FIRE RISK MANAGEMENT, INC

Memo Report

Subject: Independent Fire Protection Review for Cumberland County Civic Center Renovations

A review has been completed of the updated sets of fire protection construction documents (CD), which have been developed to support renovation efforts at the Cumberland County Civic Center in Portland, ME. The documents reviewed included both the fire protection demolition and design drawings (updated 4/12/13), along with the design specifications (updated 4/2/13) for the various fire protection and life safety related systems and the Building Code Report (dated 4/16/13).

4 BACK OF HOUSE STAIR SECTION  
 1/4" = 1'-0"

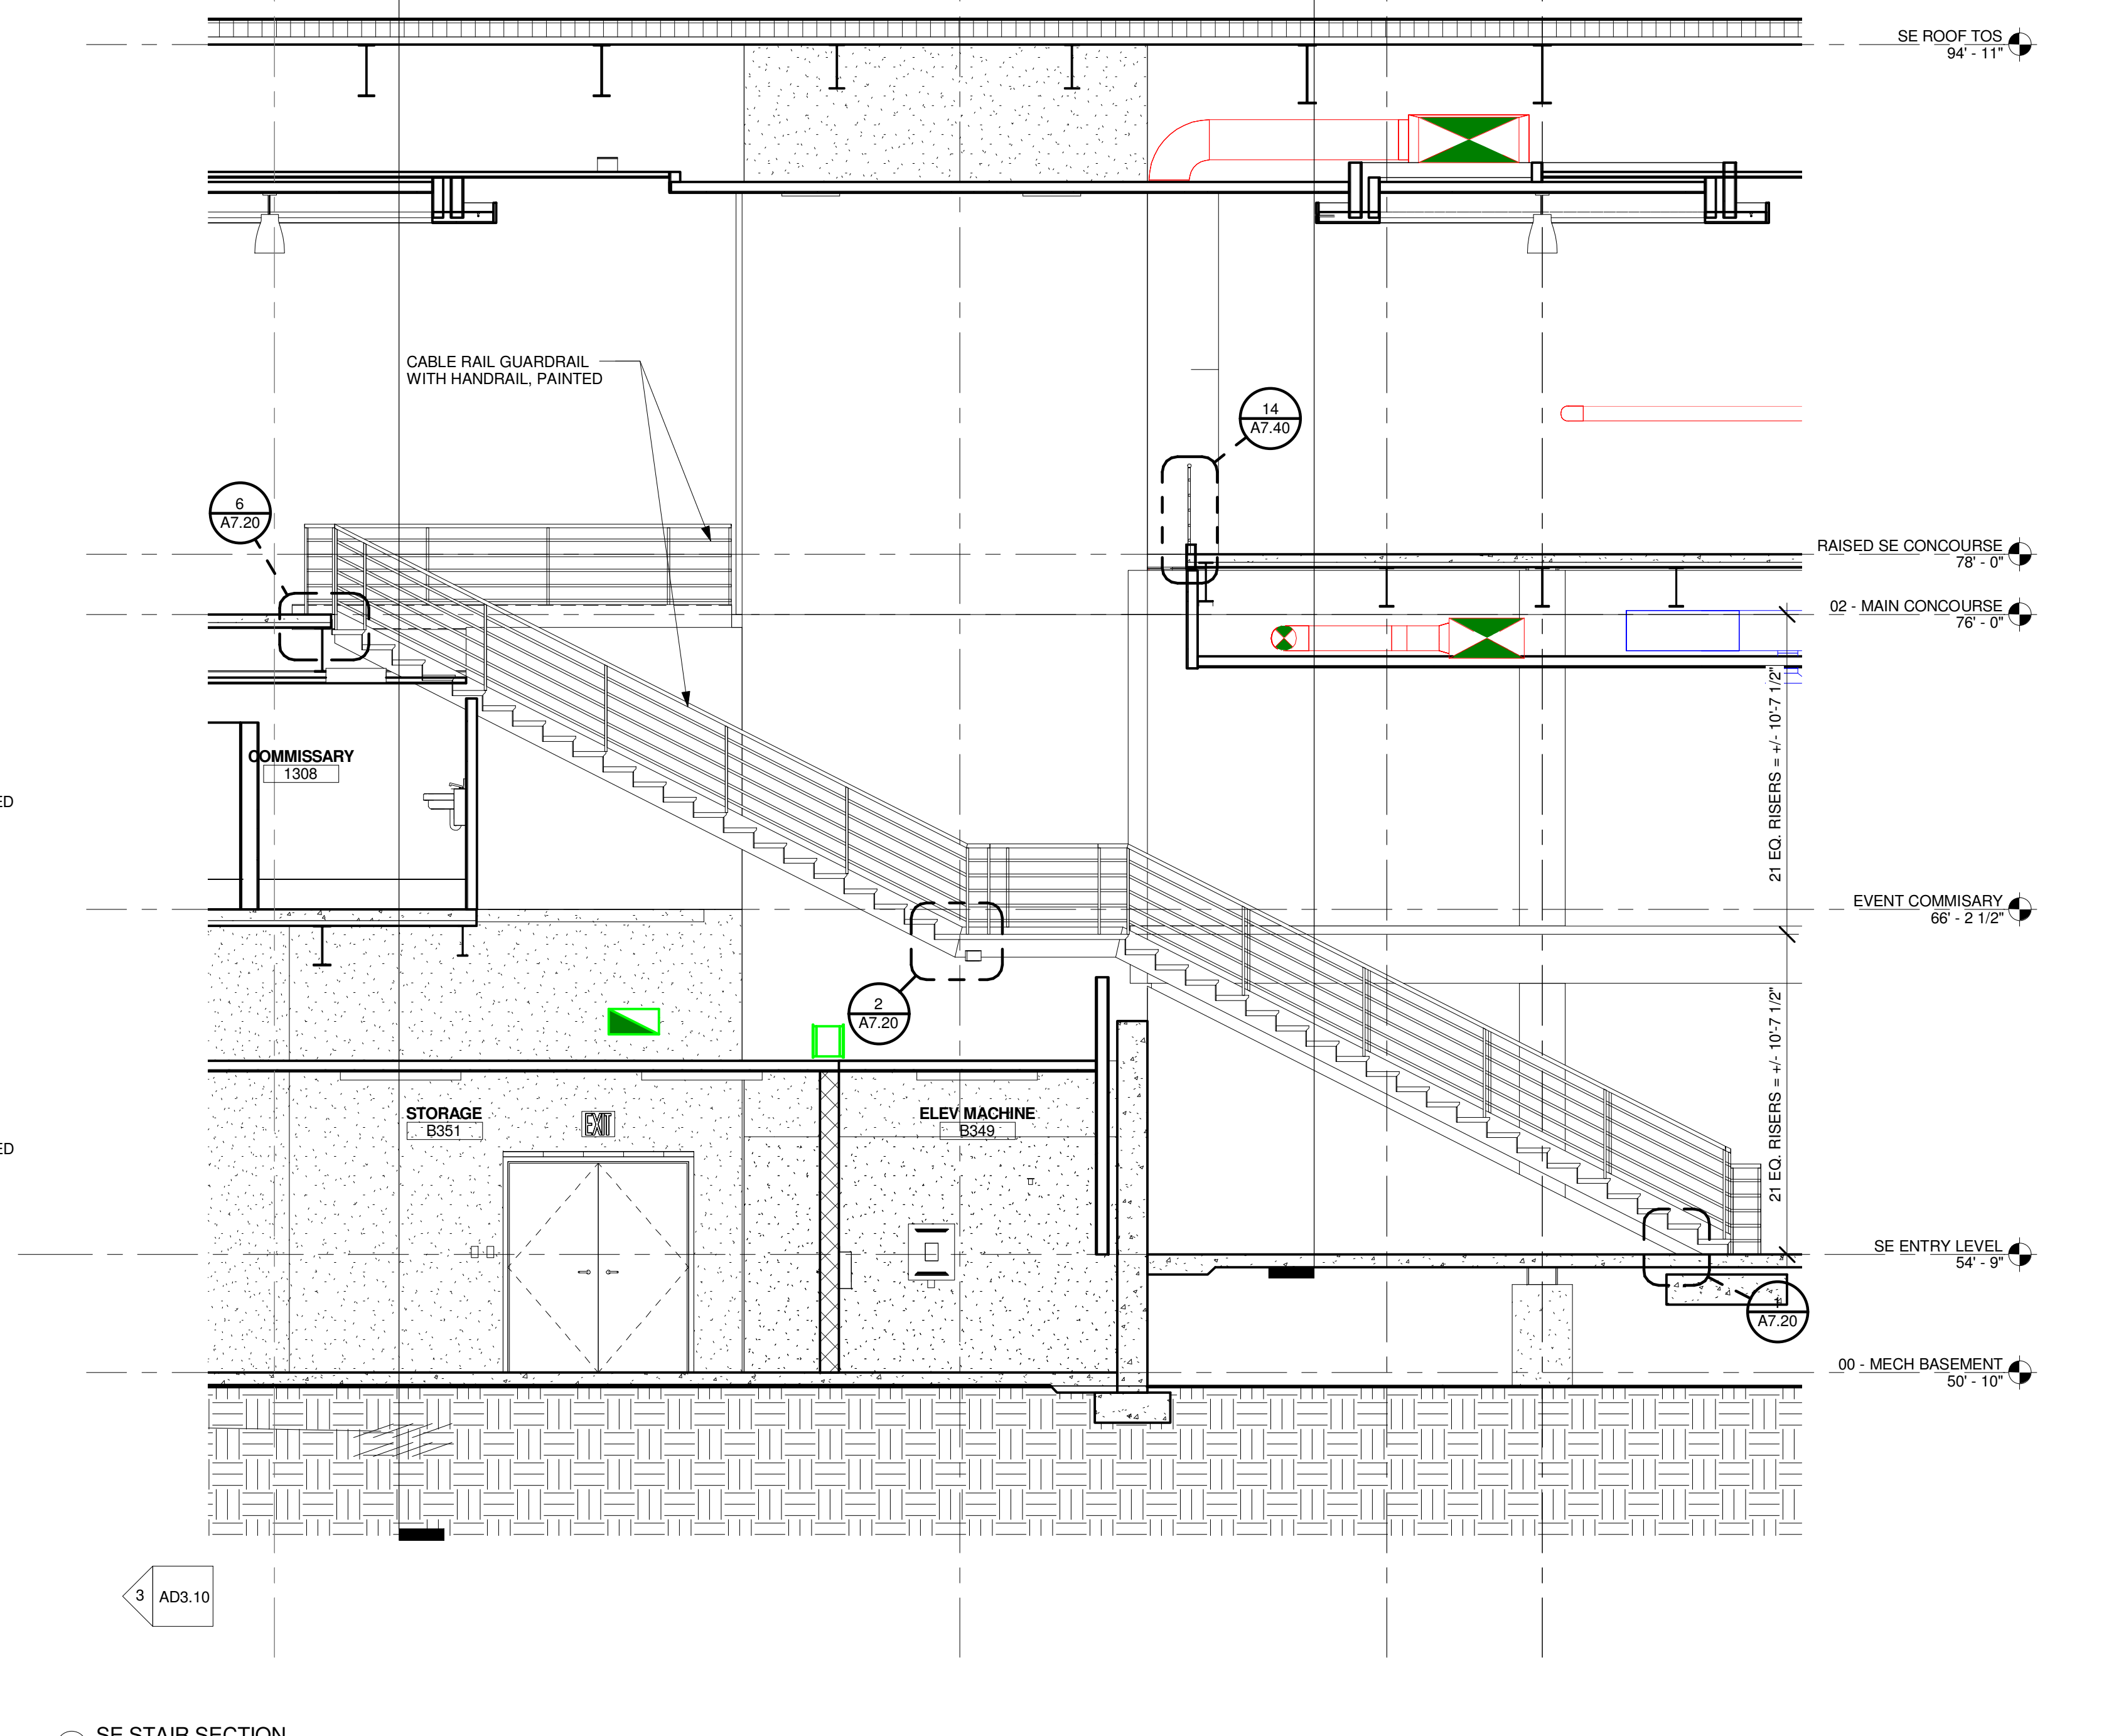
The occupant load calculations for the home team locker room and its associated spaces/areas, including office areas, do not appear to accurately reflect the load factors that should be applied within all the various spaces. Also, the stair located on the west end of the Event Level that leads up to the Concourse Level, does not appear to be provided with intermediate railings. These stairs appear to be much wider than the 5-foot (60 inch) maximum that would be allowed without the need to install additional handrails. [Note: An 88 inch maximum distance between handrails is allowed for "existing" buildings.] The current plan for the design of these stairs should be reviewed to determine if an additional handrail(s) is needed.
